City of Sydney Review Response- Waterloo Metro Quarter

It is understood that after submission of the planning documents for the Waterloo Metro Quarter Development, commentary has been provided on the submission. The comments received are noted below, with commentary in response discussed in this letter. This document is an addendum to the submitted Appendix JJ – Southern Precinct Landscape Design Report.

Deep Soil

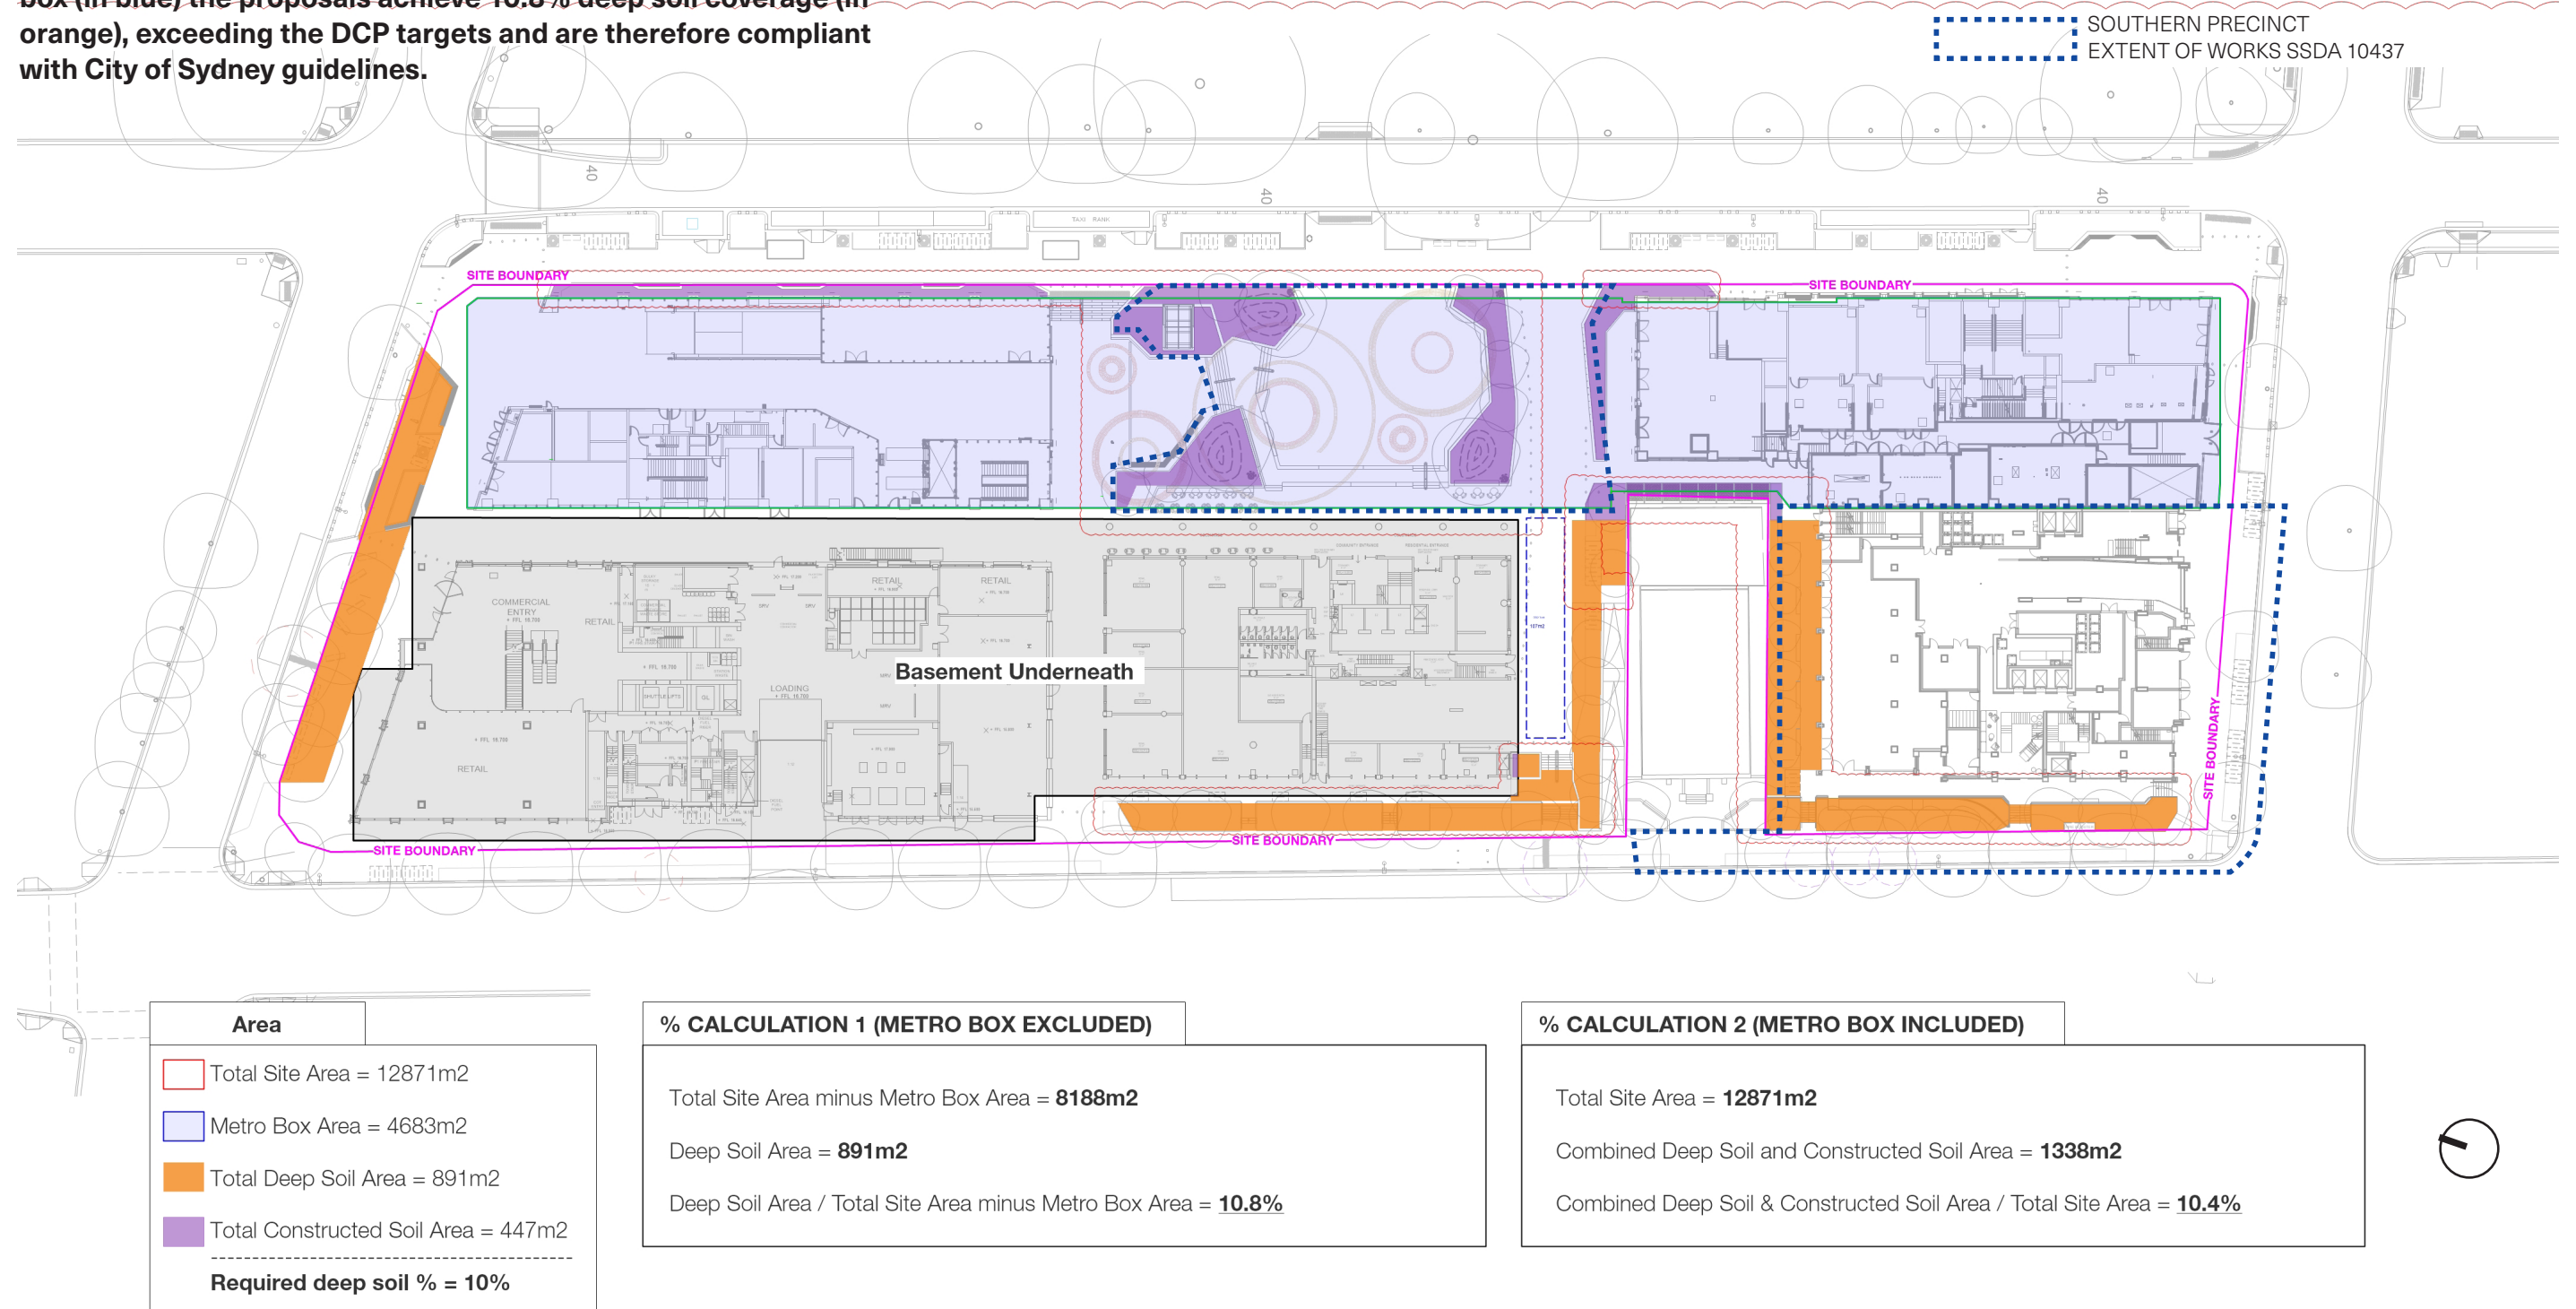
Landscaping (continued)		
38	<p><i>Deep soil – Deep soil is underprovided, equating to approximately half of the area claimed. The Sydney Development Control Plan 2012 (SDCP) and ADG both have a minimum deep soil dimension of three metres. Many of the proposed garden beds are less than this three metre minimum and it is noteworthy that the remaining quantity of compliant deep soil relies heavily on permeable paving. City staff calculate that approximately 470sqm or 5.7% of the site area is allocated to deep soil.</i></p>	<p>Deep soil areas have been amended and the calculations now only include soil areas with a minimum width of 3m. This includes a 3m wide deep soil area to the Botany Road frontage, removing raised planter retaining walls and providing a continuous planting area with steps bridging this space and permeable surfacing to the cantilevered ramp. The deep soil area allocated to the site now measures 10.4%.</p> <p>Refer to Southern Precinct Landscape Design Report page 15 'Deep Soil'.</p>
